ESTATES OFFICE

27 March 2020

Application Ref.: F/5/20/PL
Applicant: Ford Airfield Market
Proposal: Reconfiguration of Ford Market, including revised market access, hardstanding for replacement vehicular parking and associated infrastructure, landscape, ancillary and site preparation works.
Location: Ford Airfield Market Ford BN18 0FL

FIGURE 4: PROPOSED SITE PLAN

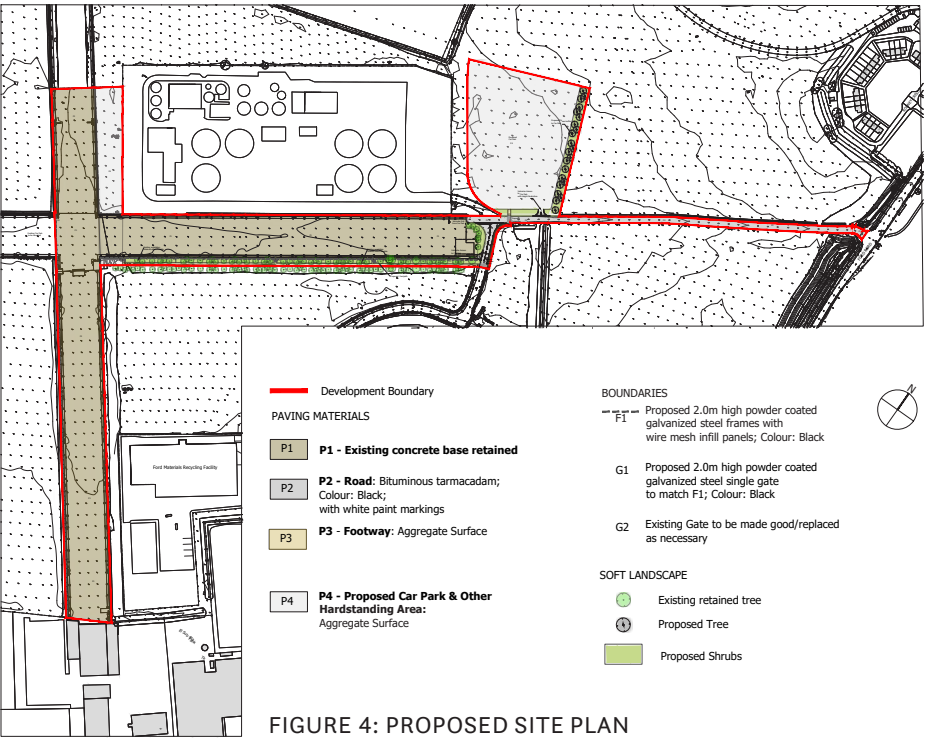
We note that the plans included in the planning application for the Ford Airfield Market reconfiguration (such as the proposed site plan or the proposed access arrangements) do not show the Ford CTP site new access road (which runs alongside the wastewater treatment works). The new access road to the Ford CTP site is now completed and in use.

We are also extremely concerned with the proposed layout for the market reconfiguration, and in particular the proposal for the new overflow car park immediately to the east of the CTP site's new access road. This would create a new access point and a new pedestrian crossing in very close proximity to the CTP access point, with the associated issues in terms of safety and conflicts between vehicles visiting our site and the users of the market. The vehicles visiting the Ford CTP site are heavy goods vehicles, essentially Refuse Collection Vehicles or articulated lorries and therefore, there is a clear and untenable conflict between these vehicles turning in and out of the Ford CTP access road and pedestrians crossing the road from the overflow car park to access the rest of the market.

FIGURE 5: MARKET ACCESS ARRANGEMENTS

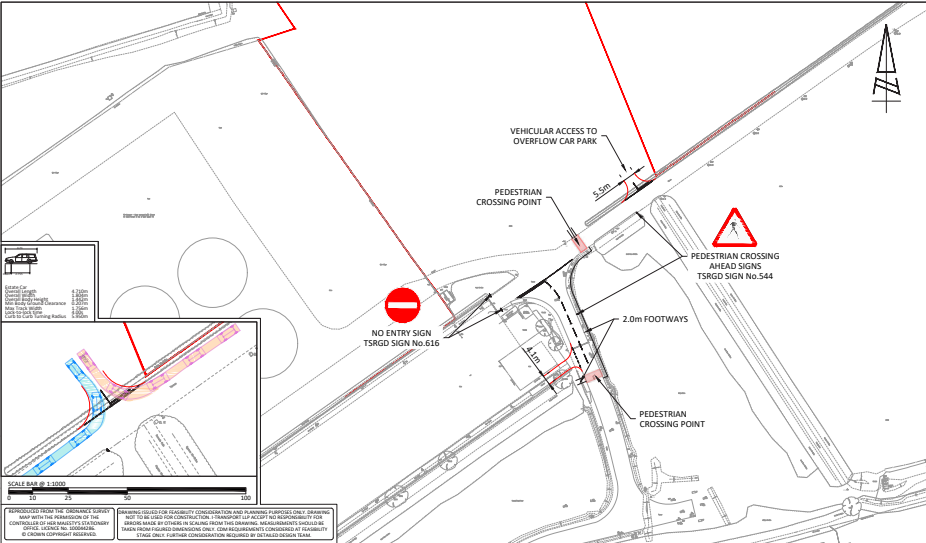
Whilst the application does not seek to intensify the overall use of the market, it proposes one single point of access to the east off Ford Road, diverting all traffic visiting the market onto Ford Road and the existing service road ('Hunterford'), which also leads to the Ford CTP new single point of access. This will, in effect, significantly increase vehicular traffic at the junction of 'Hunterford' with Ford Road.
